From: Laura Gibbons <Laura.Gibbons@arun.gov.uk>
Sent: 15 December 2020 14:28
To: Planning.Responses <Planning.Responses@arun.gov.uk>
Cc: Simon Davis <Simon.Davis@arun.gov.uk>
Subject: RE: Planning Consultation on: Y/71/20/RES

Engineers Comments Regarding Surface Water Drainage

Application No: Y/71/20/RES

Description of Works: Approval of reserved matters following outline consent Y/88/18/OUT for the erection of 38 No. dwellings, Public Open Space, a play area & drainage features. This application affects Public Rights of Way.

Rev	Amendments	Drn	Chk	App	Date
Scale	@A3	Date	SEP 2020	Designed	AK
Drawn	AK	Checked	SW	Approved	SW
Job No	19-156	Drawing No	YAP-130-27	Rev	-

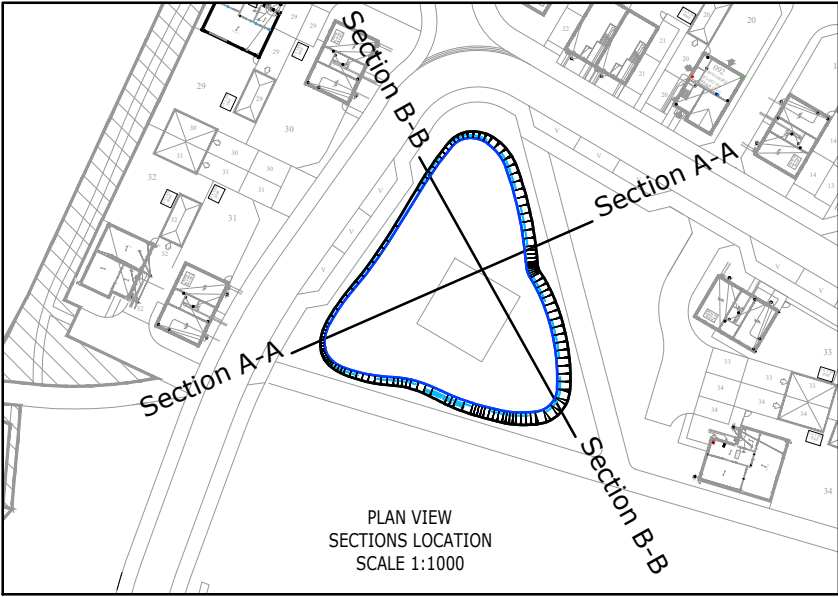
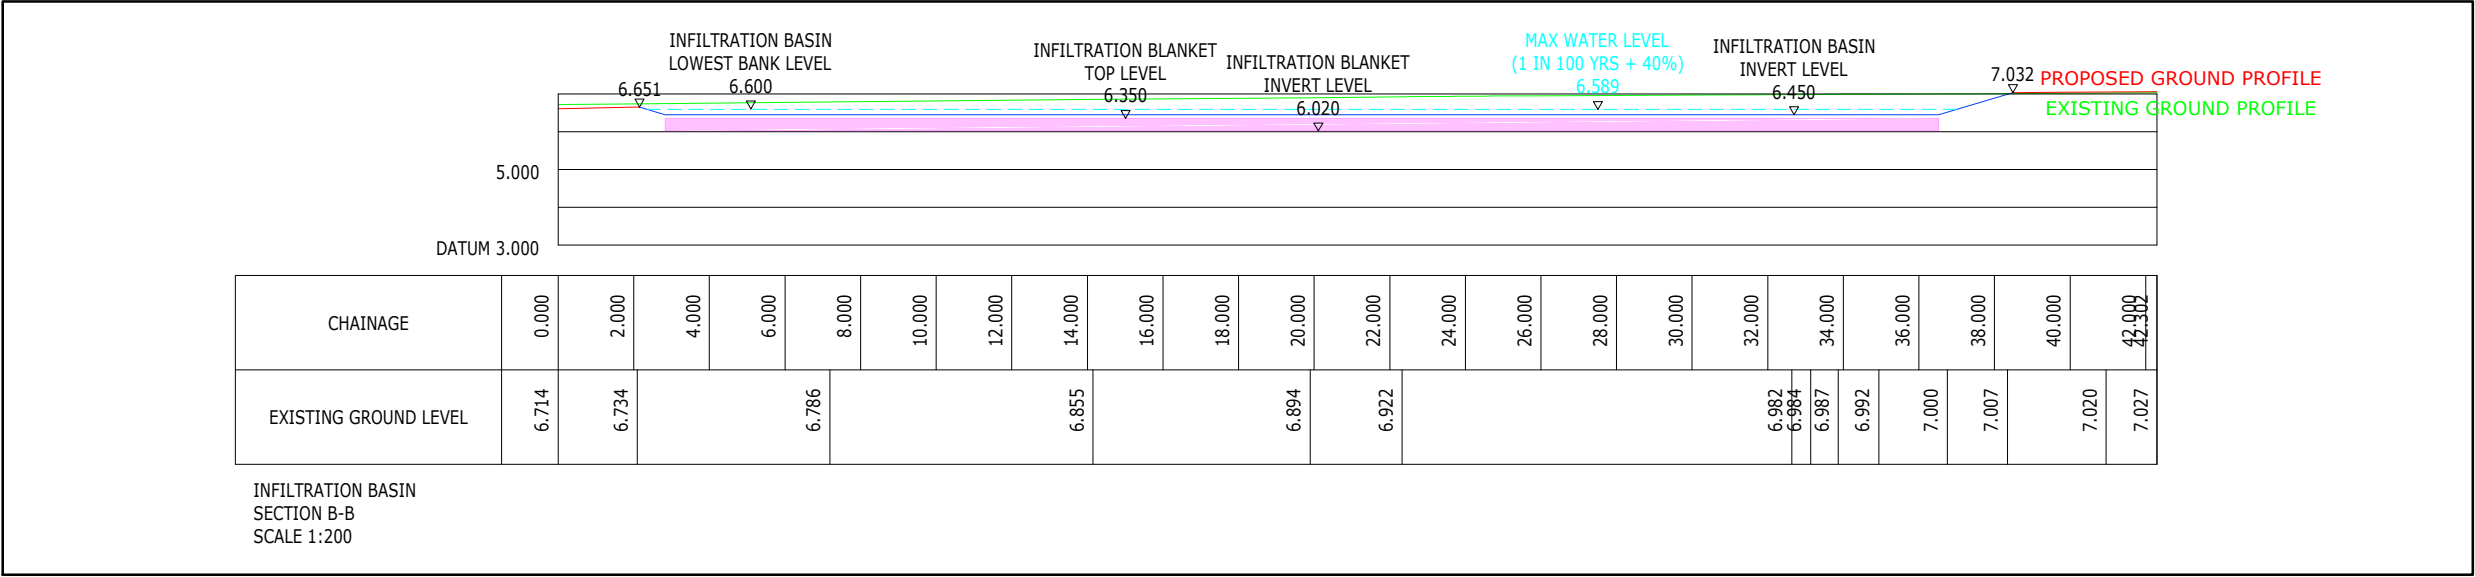
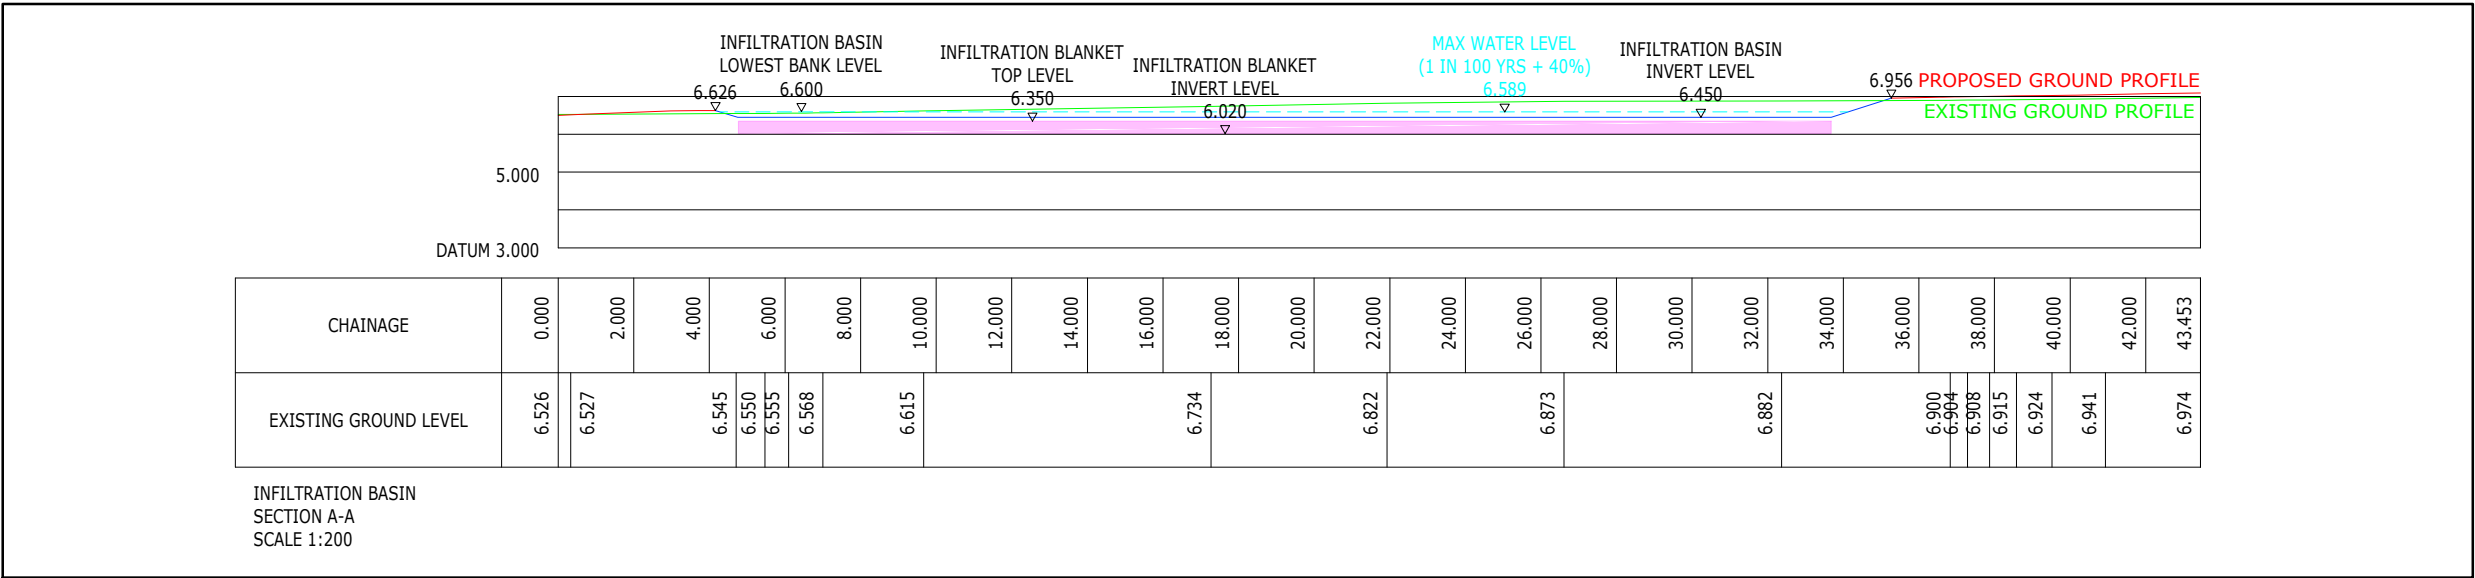
To confirm, we maintain our holding objection at this time, as detailed in our previous responses. It has not been evidenced that there is adequate space for surface water drainage.
